From: Laura Gibbons [REDACTED]
Sent: 04 August 2020 15:40
To: Planning.Responses <Planning.Responses@arun.gov.uk>
Cc: Maria Tomalova <Maria.Tomalova@arun.gov.uk>
Subject: BE/70/20/DOC- Land at Phase 1A Oldlands Farm

Thank you for consulting us regarding conditions 6, 7 and 8. We have the following comments:

Condition 6- surface water drainage design

Project No:	Scale (@A1):	Drawn:	Date:
1620003993	1:500	BW	JUN.19
Drawing No:	Rev:		
RAM-0500-01A-DR-CR-20001	P04

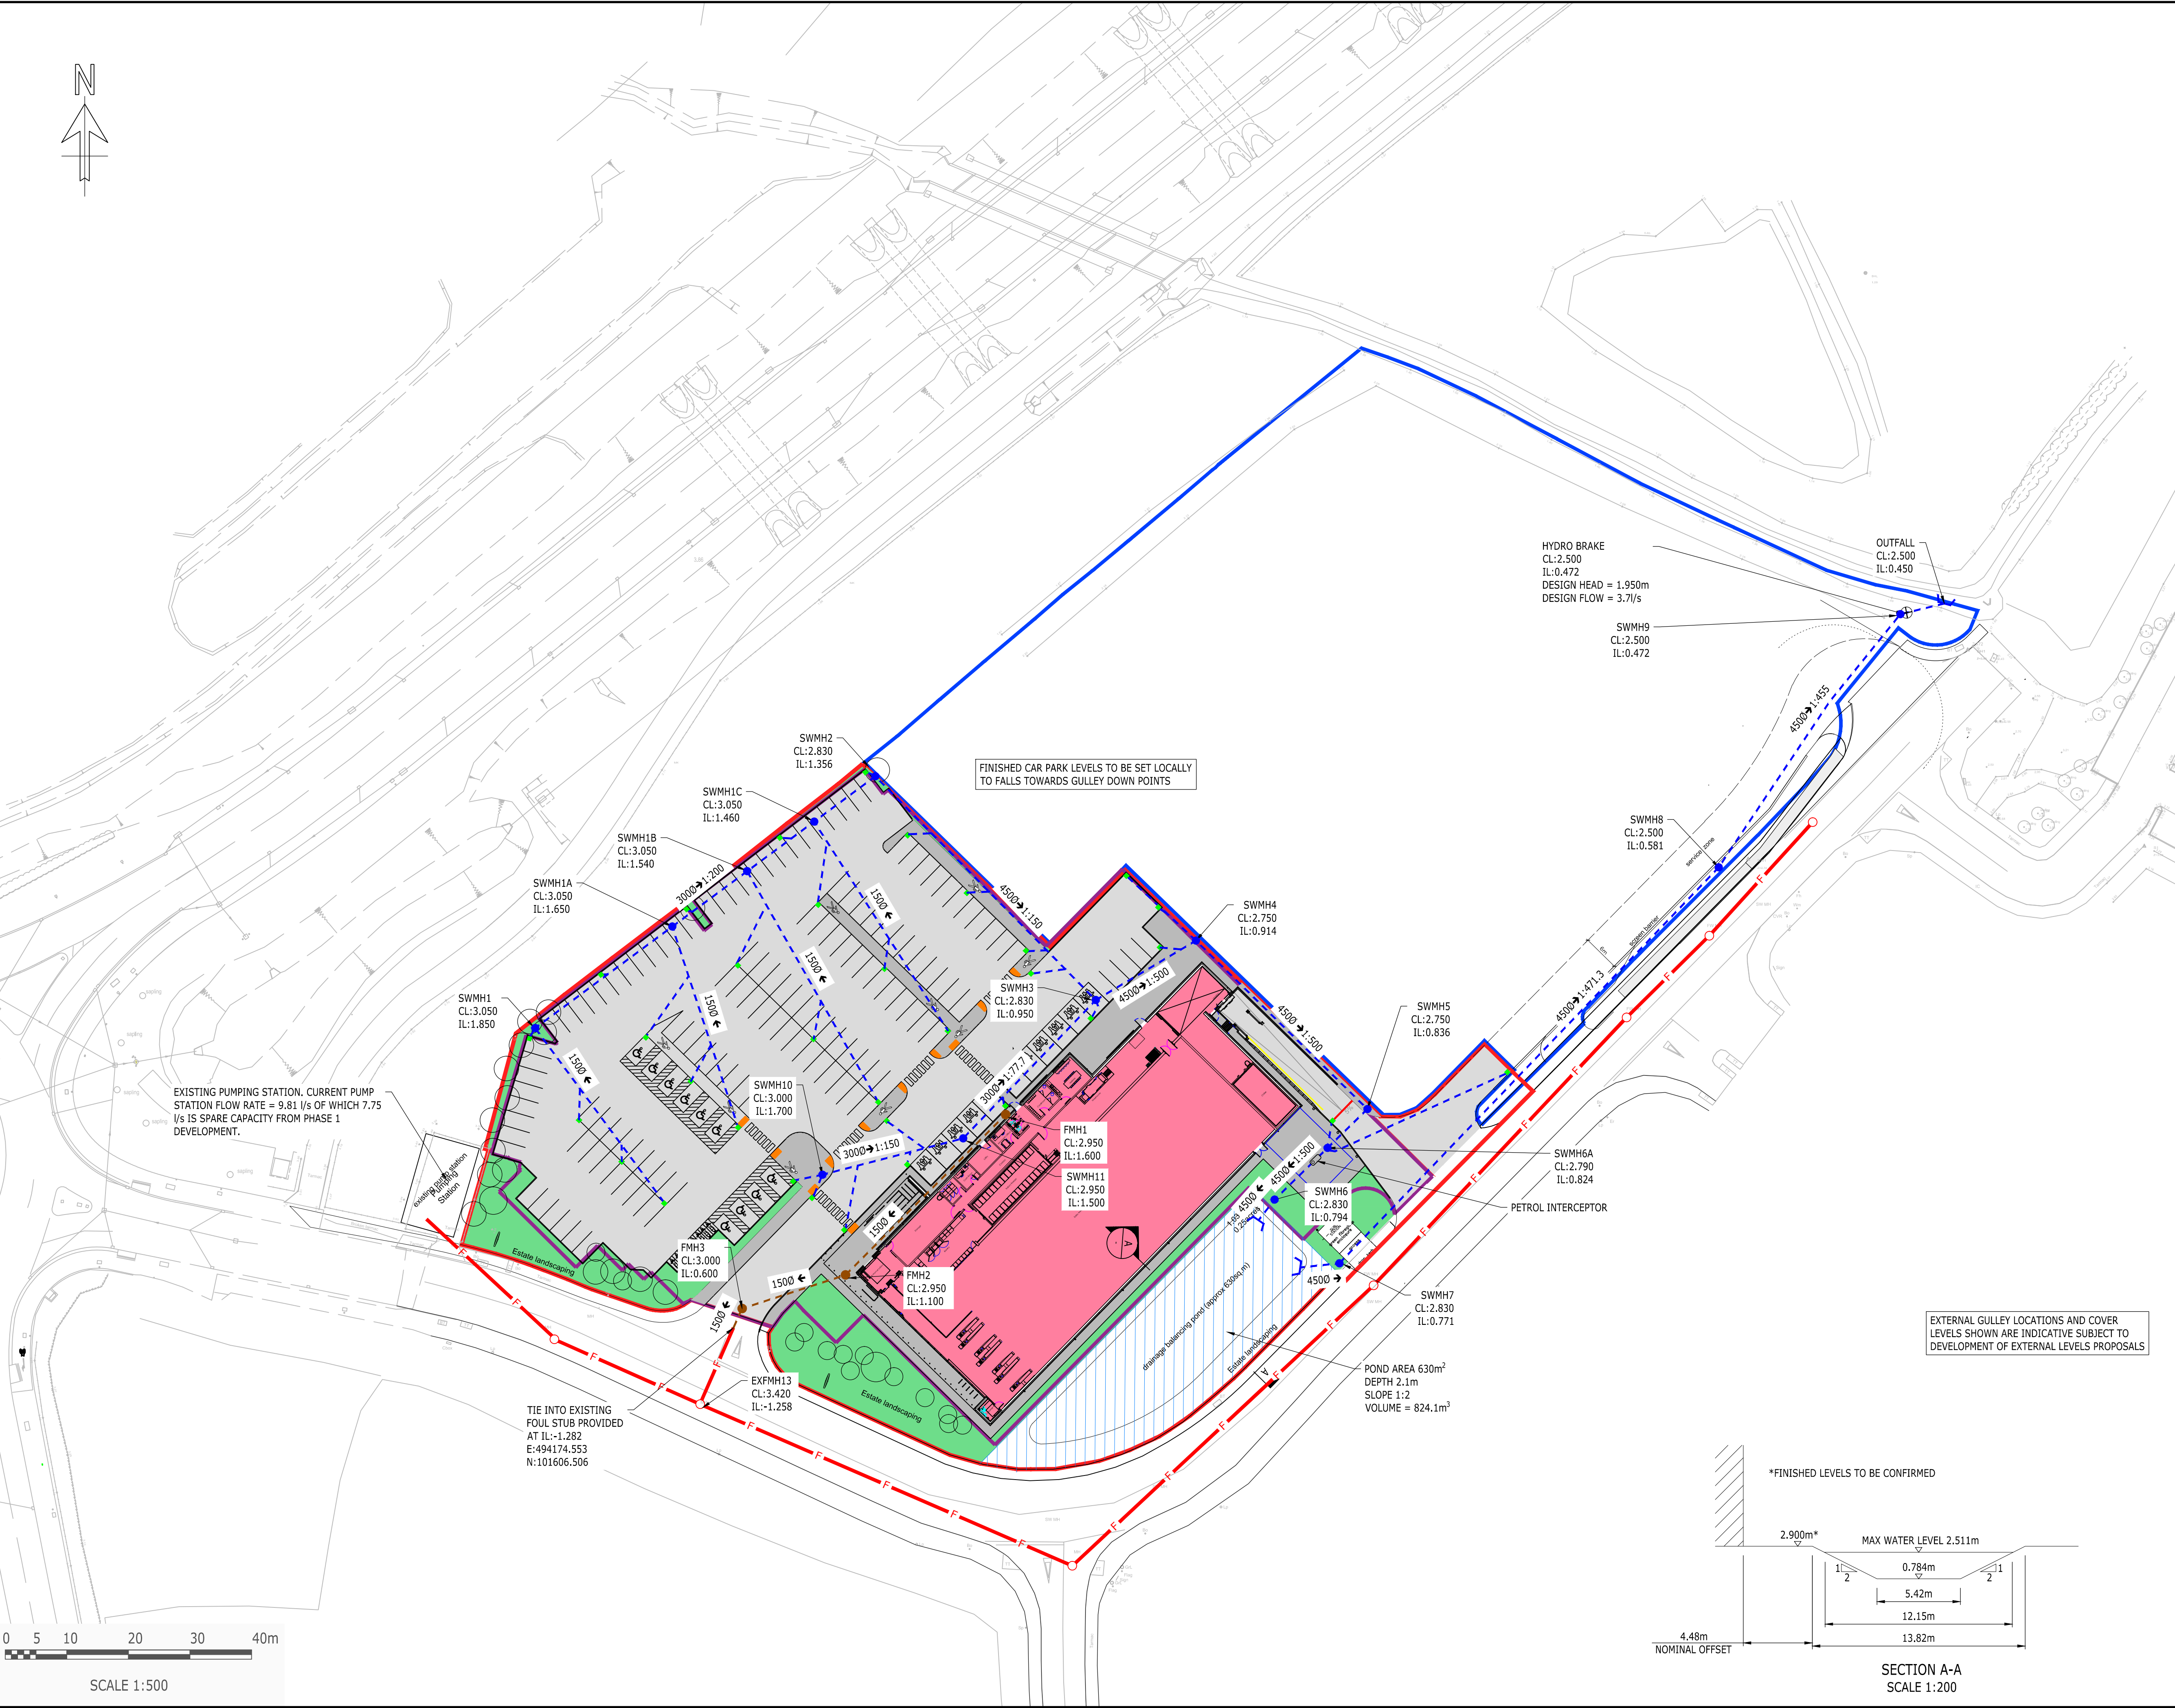
2. Please model a surcharged outfall with water levels set to adjacent top of bank level as a conservative assumption.
3. Please include printout from Microdrainage evidencing impermeable areas modelled.

4. We note that MicroDrainage has been set to autodesign pipes to achieve 0.75m/s, 1 m/s must be achieved. Please include a printout from MicroDrainage indicating velocities achieved in pipes.

Project No:	Scale (@A1):	Drawn:	Date:
1620003993	AS SHOWN	BW	JUN.19
Drawing No:	Rev:		
RAM-0500-01A-D-CR-20101	P04

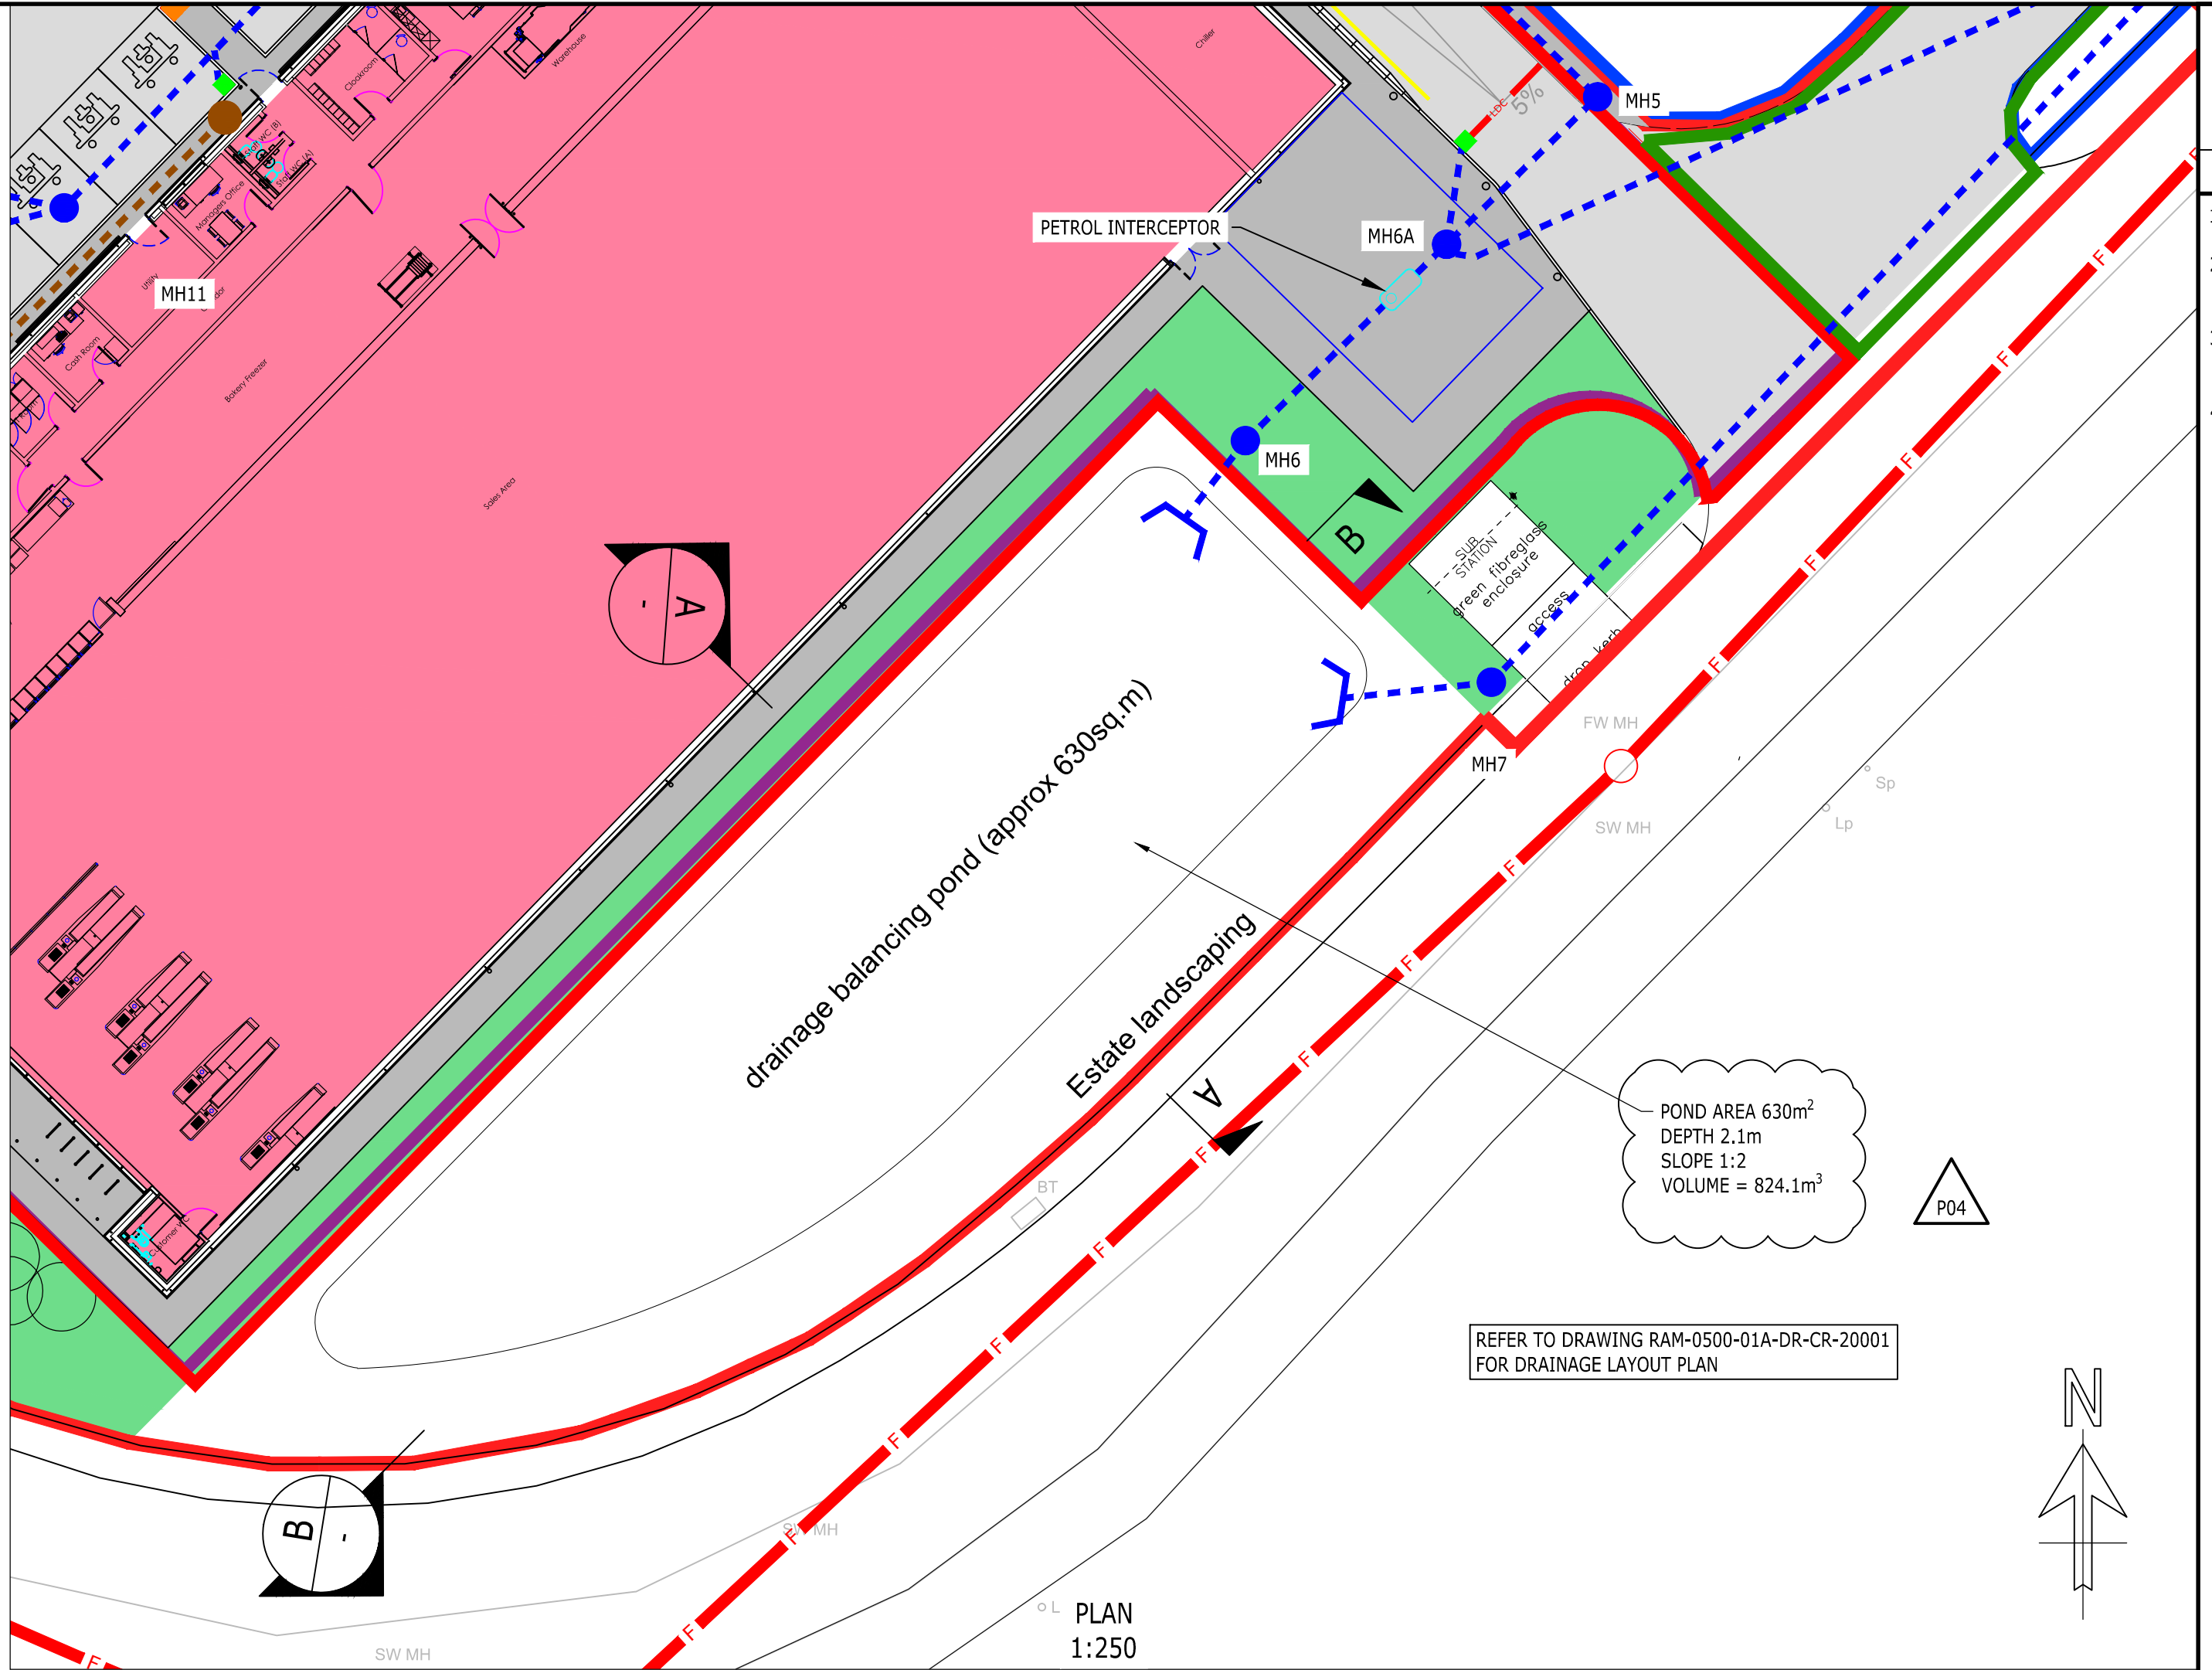
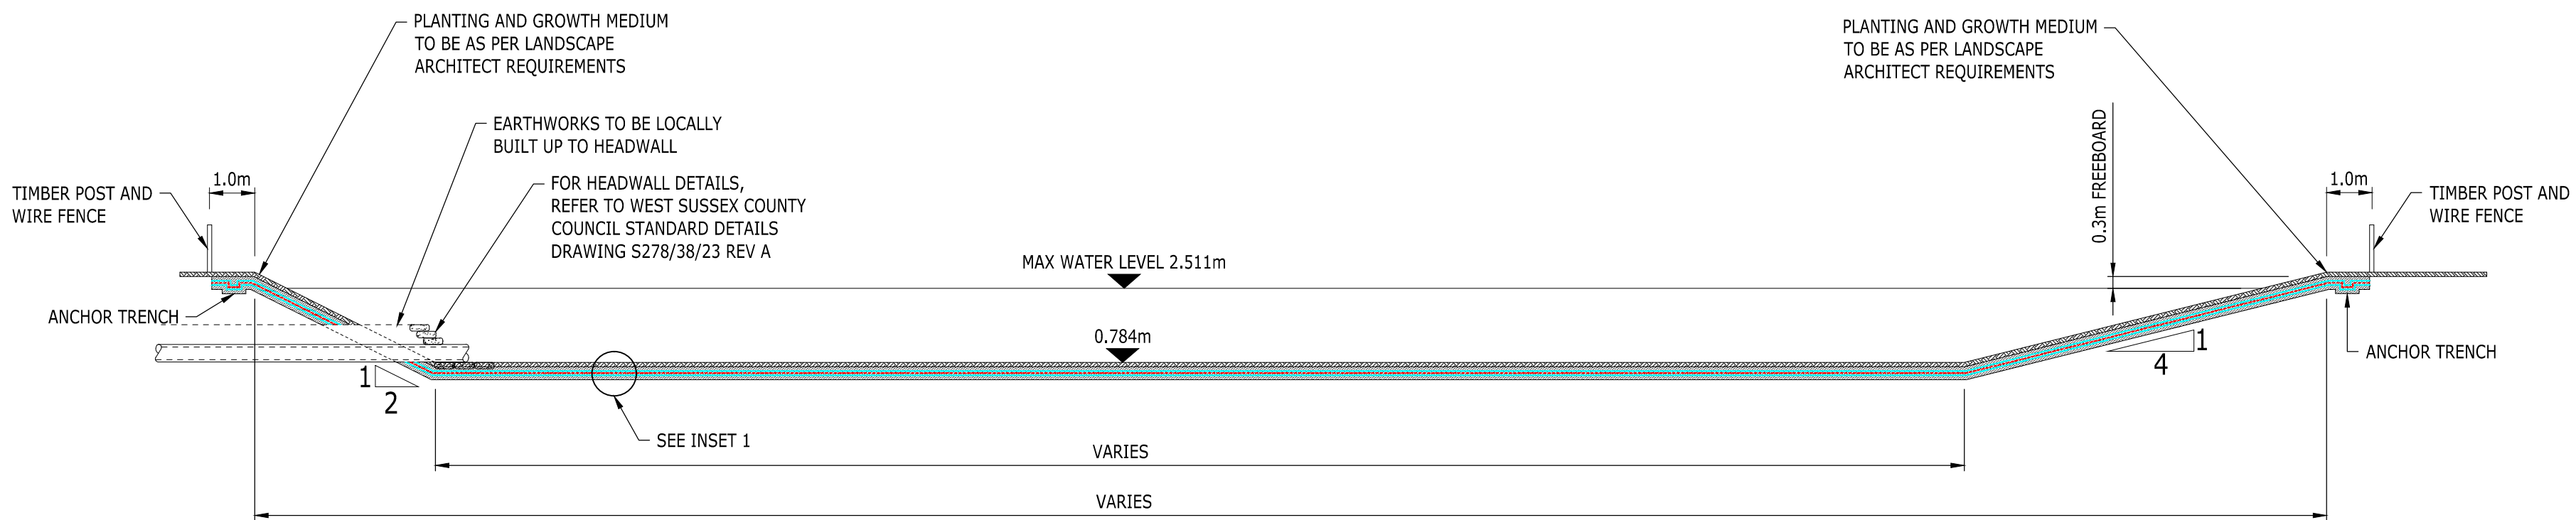
5. Pond cross sections have been provided, these indicate slopes are to be set to 1:2. 1:3 slopes should be provided.
6. It appears that a post and rail fence is proposed 1m from the top of bank of the attenuation basin. We require a 3m clear buffer around the basin to facilitate future maintenance.
